**From:** Joey Davis <joey@dclugston.com>  
**Sent:** Thursday, November 17, 2022 9:55 AM  
**To:** Cynthia Pierce  
**Subject:** RE: Wood Grove

Thank you for taking the time to review and email me about Woodgrove.

2 SP3 Return & Suction Plan 3/16" = 1'-0"

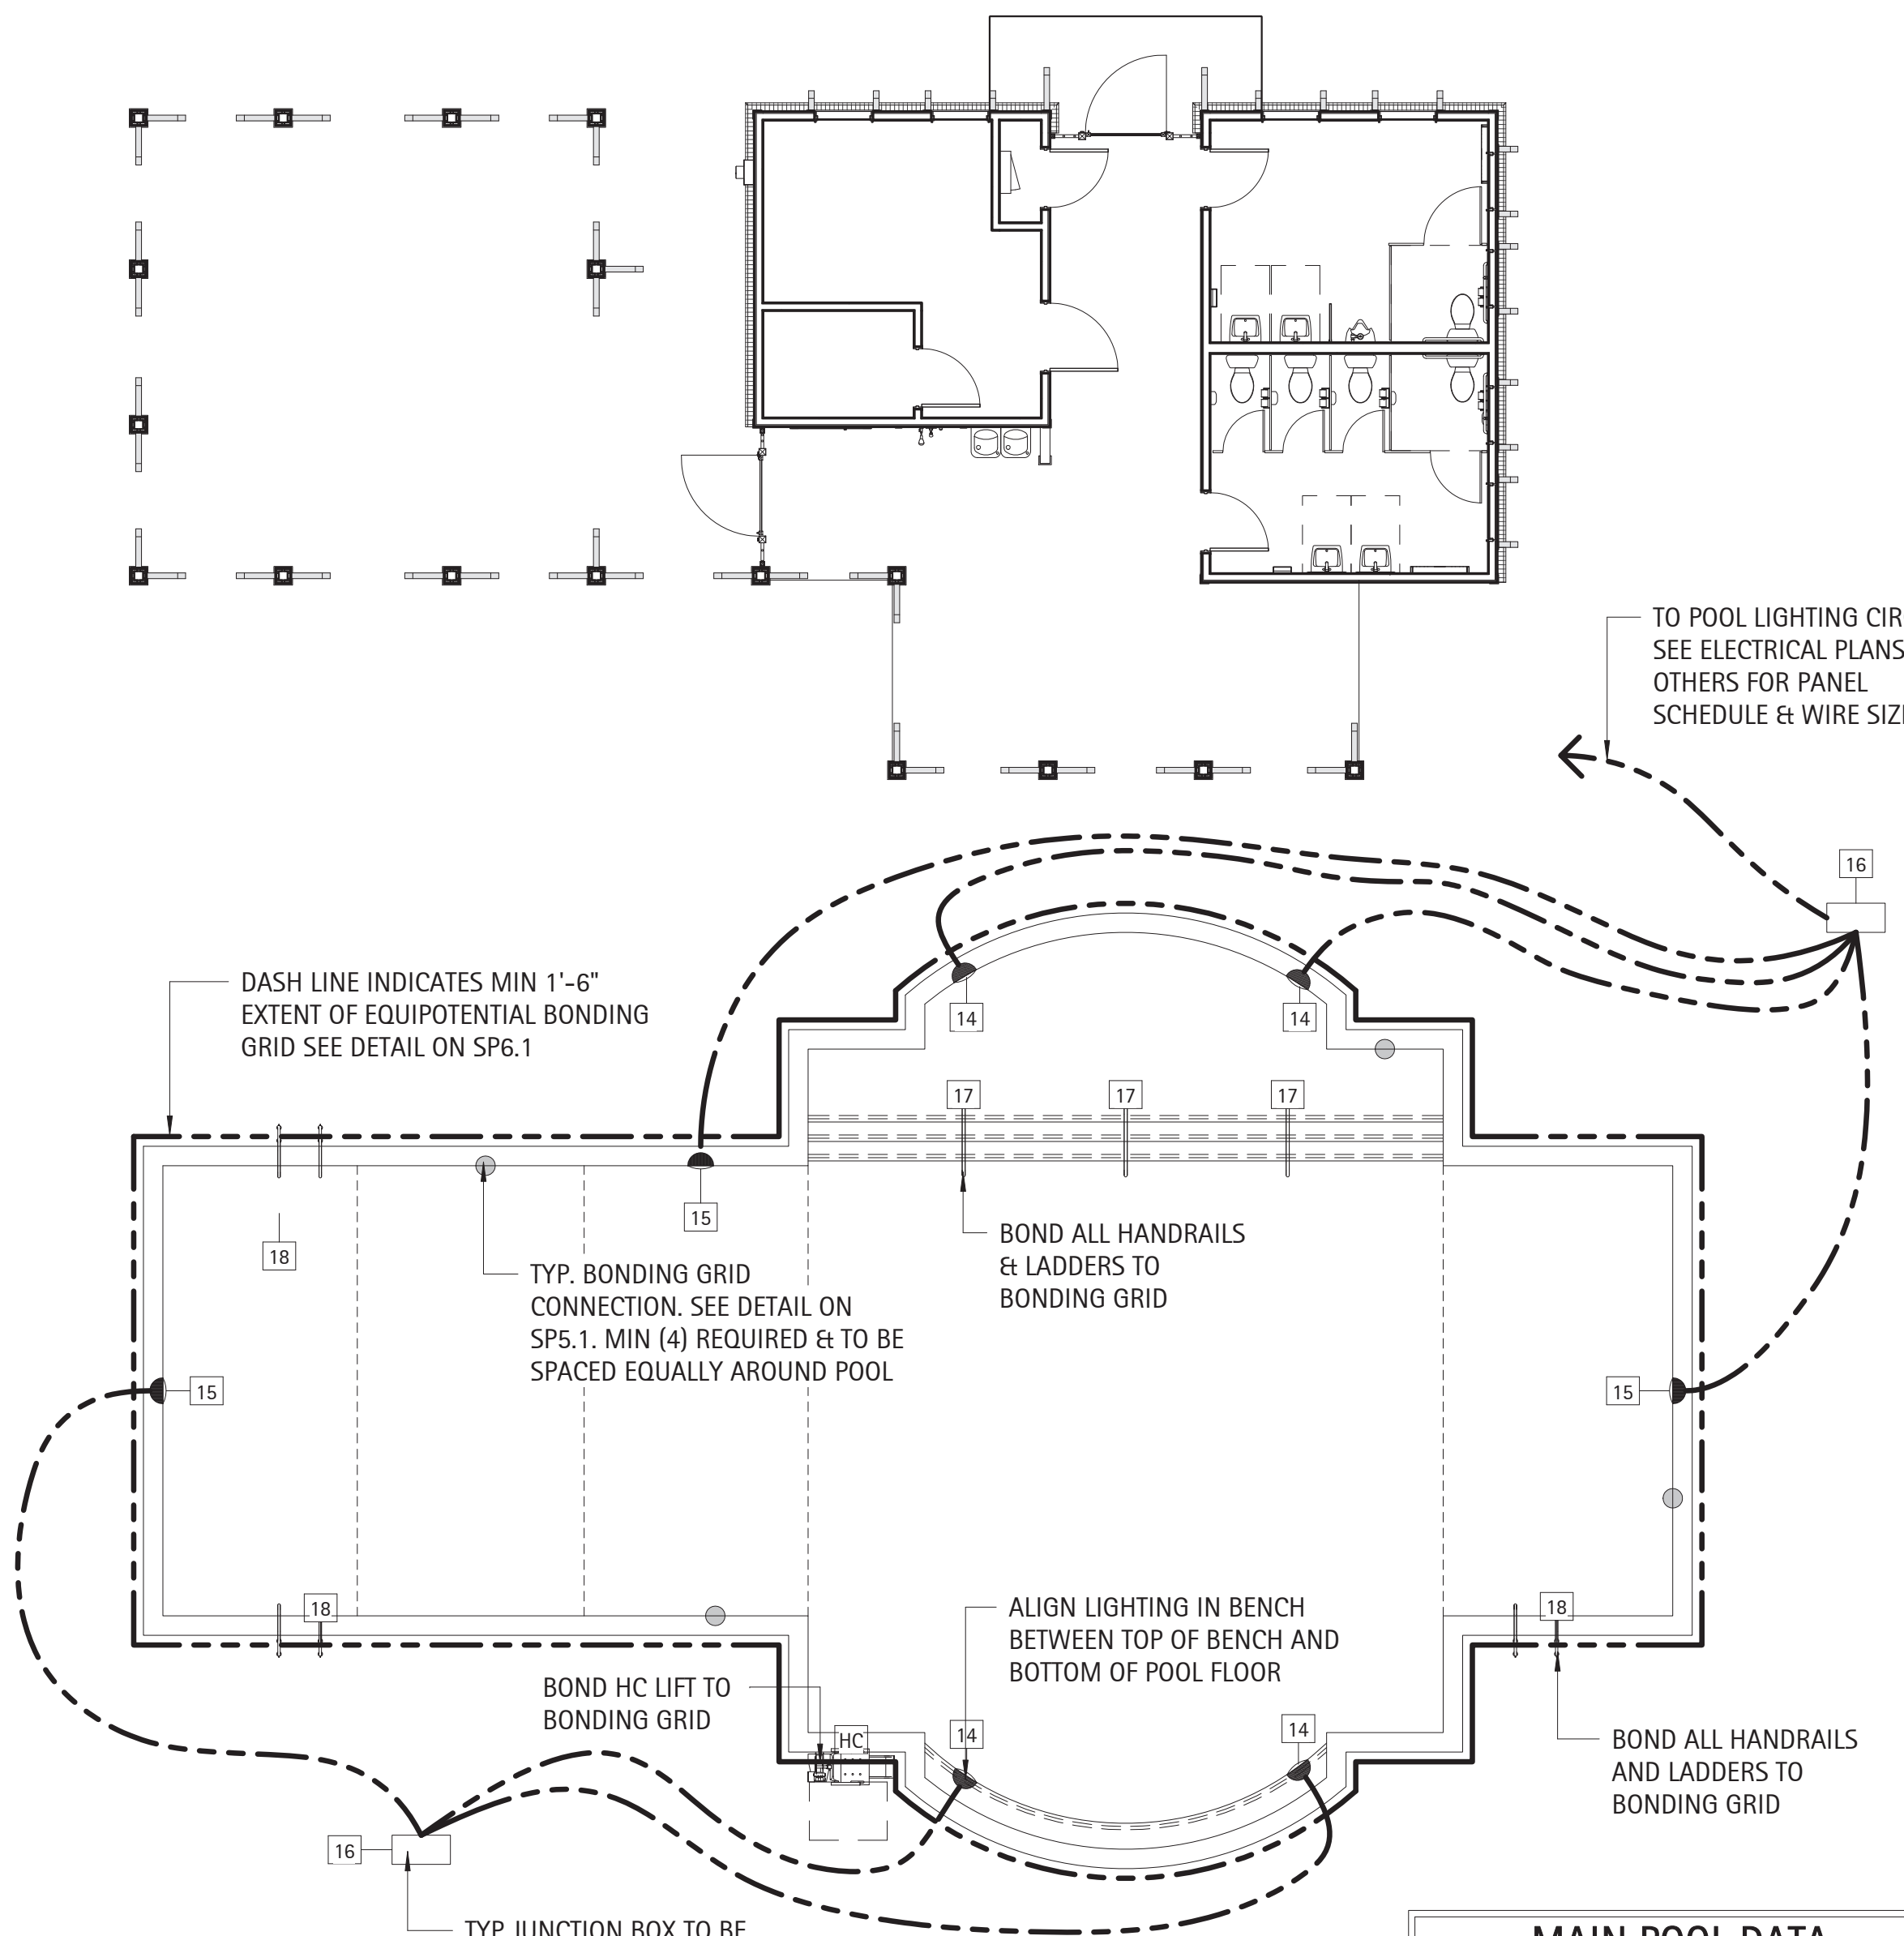
4. The autofill line is reflected on P2 water supply but is not included on the SP4 enlarged pump room plans.
  - a. The autofill line will come directly from the RPZ in the pump room and run underground to the pool. Depending on the project, I don't typically show this in the enlarged pump room plan but can include it in the future if you would prefer. I do show the autofill line coming from the pump room to the pool on SP3.2 (Return & Suction Plan).
